# CITY OF ALBUQUERQUE

**Re: Valley High School**  
**1505 Candelaria Rd NW, Albuquerque, NM 87107**  
**180-Day Temporary Certificate of Occupancy- Transportation**  
**Development**  
Engineer's Stamp dated 11-25-15 (G13-D010)  
Certification dated 09-29-16

TRAFFIC CIRCULATION
LAYOUT PLAN

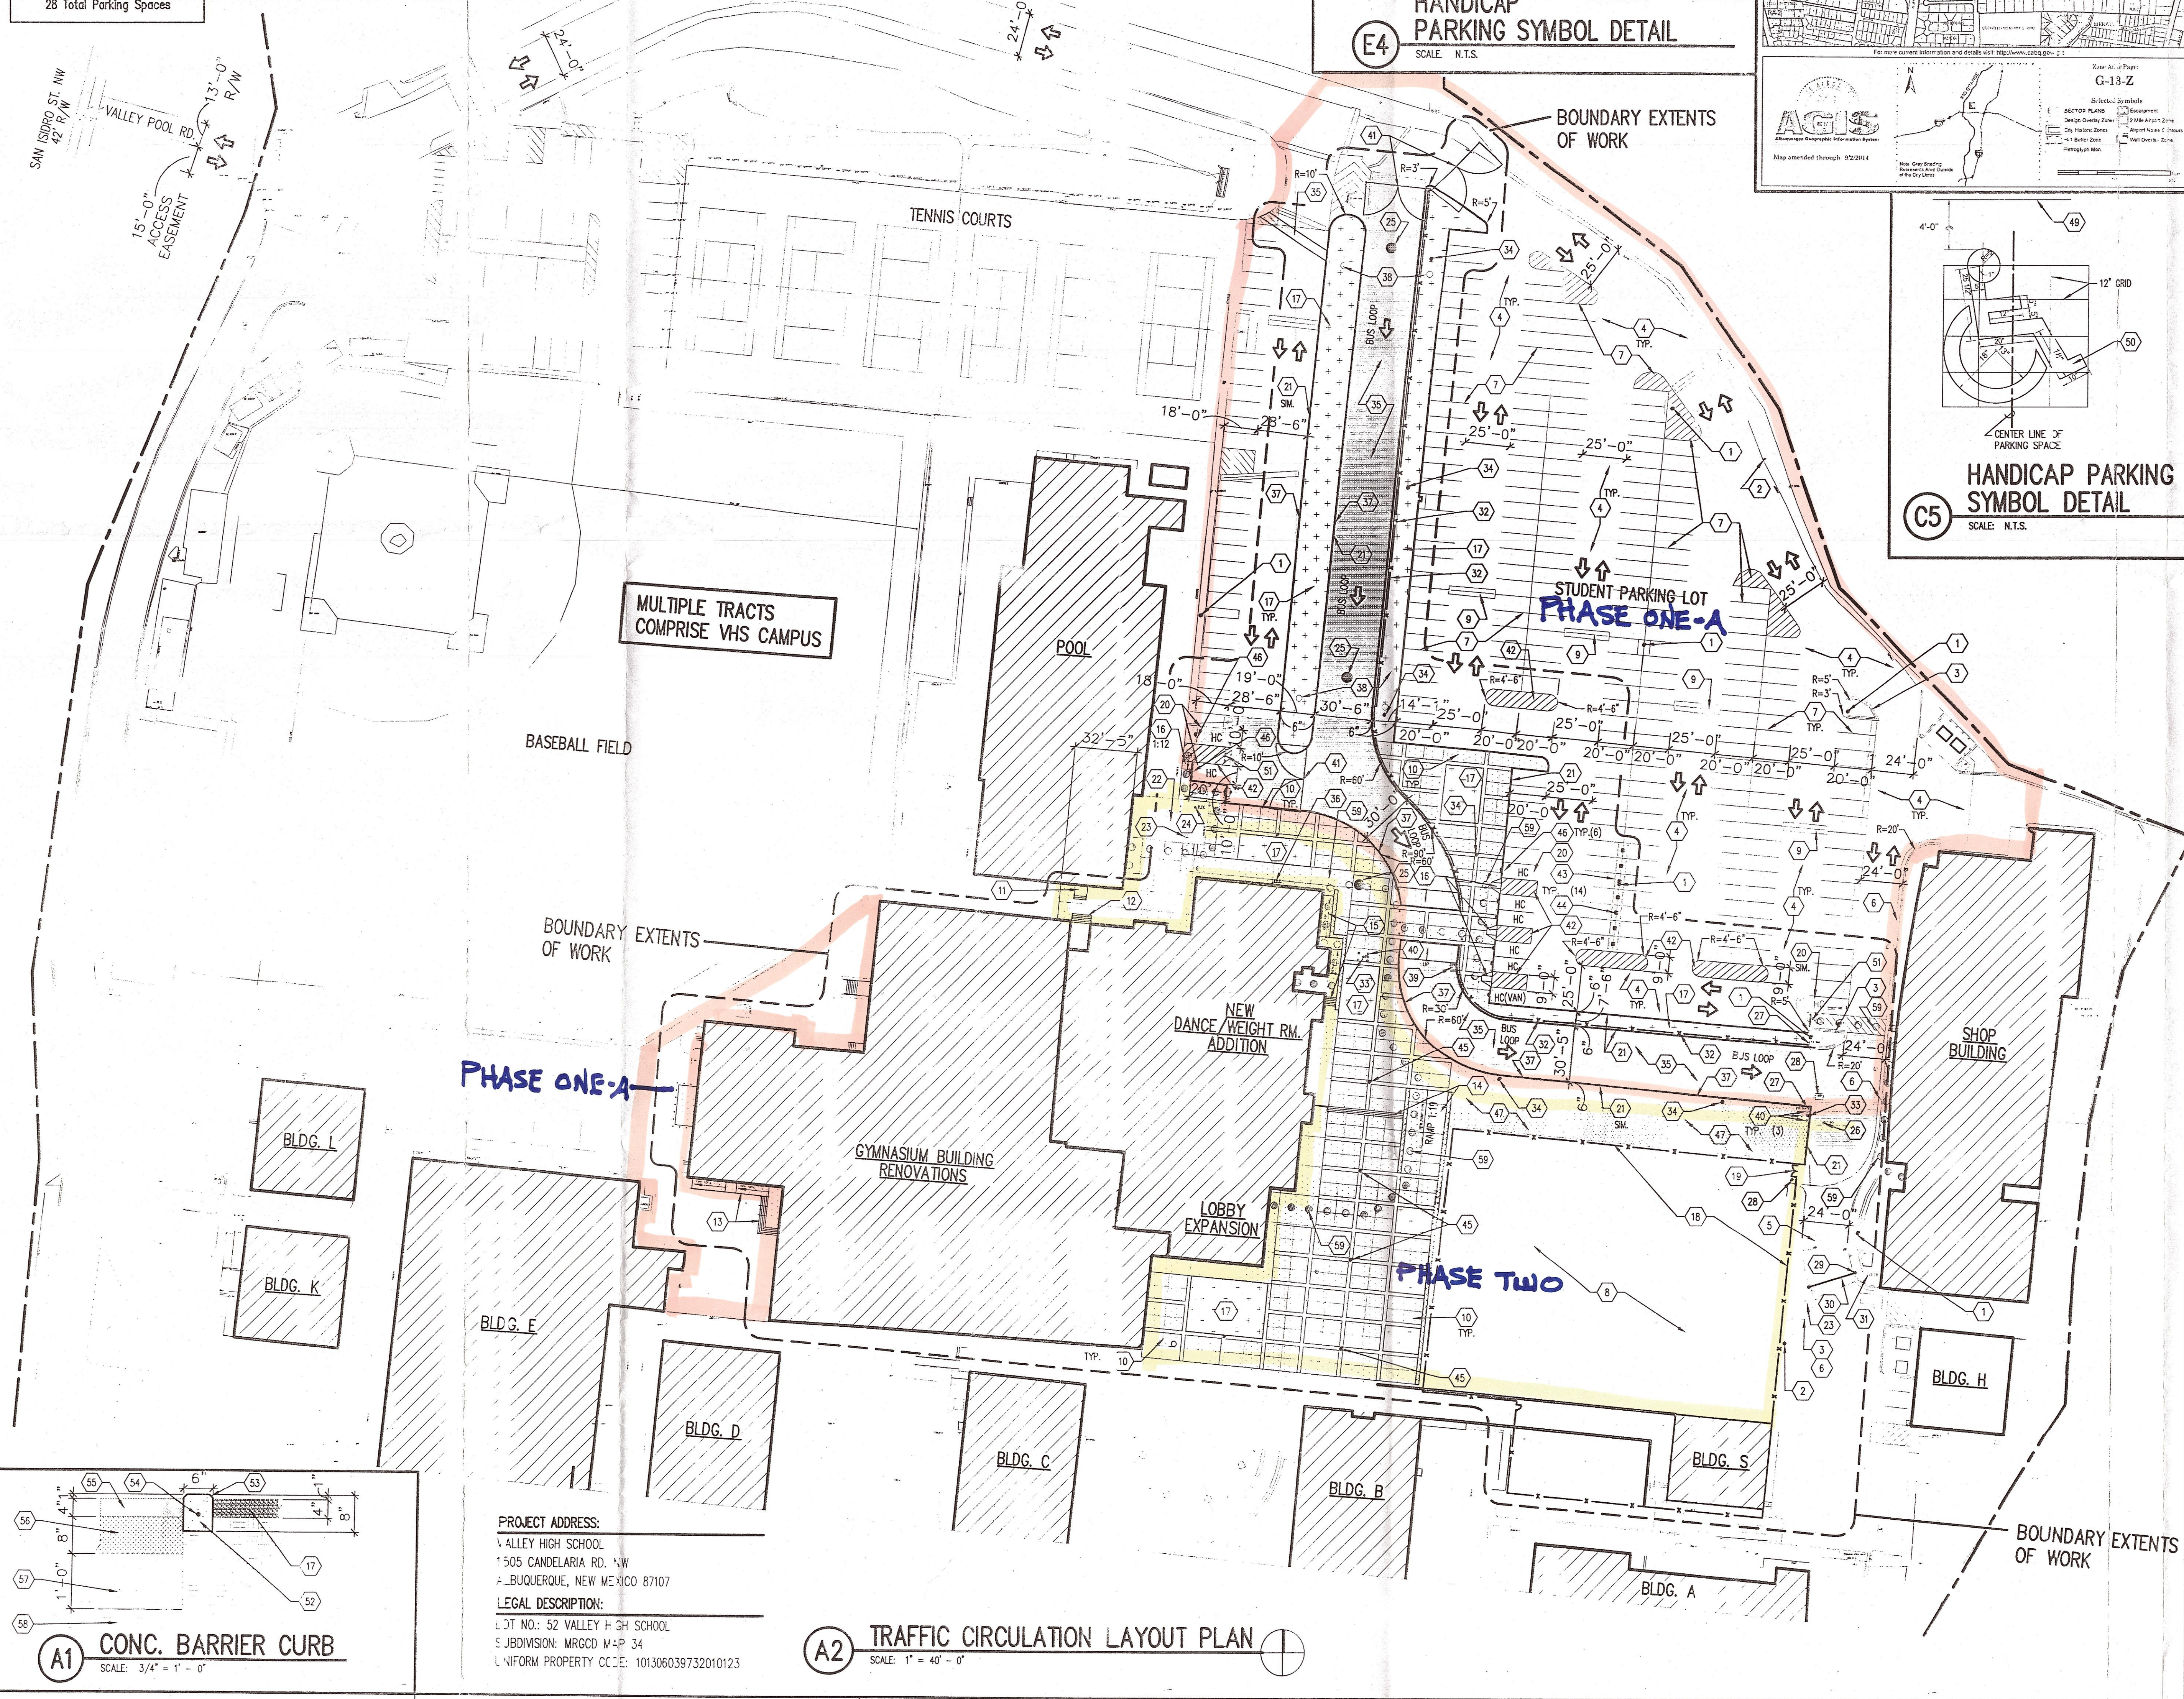
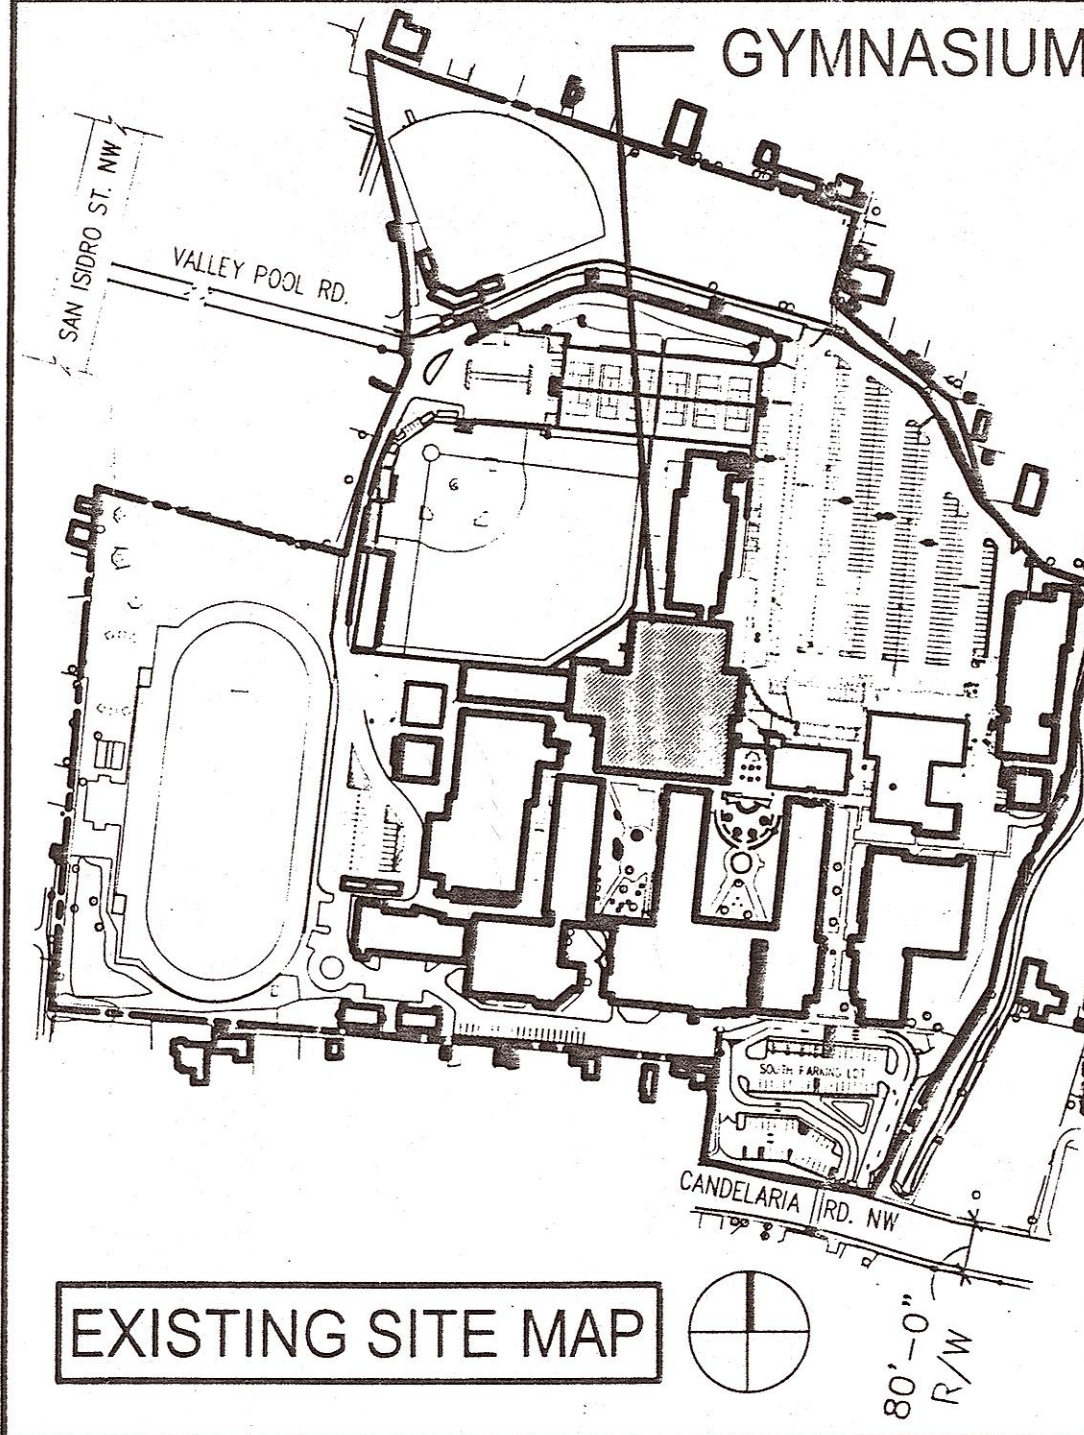
1. The abandoned drainage pipe at the north end of the parking lot shall be barricaded or filled in to prevent vehicle rollover.
2. All construction equipment, vehicles, construction fencing and trailers shall be removed from site location.
3. Provide a key way at the south van accessible parking spot where construction equipment is currently staged until equipment is relocated. (This is to allow room for vehicles to turn around when the staging is present.)
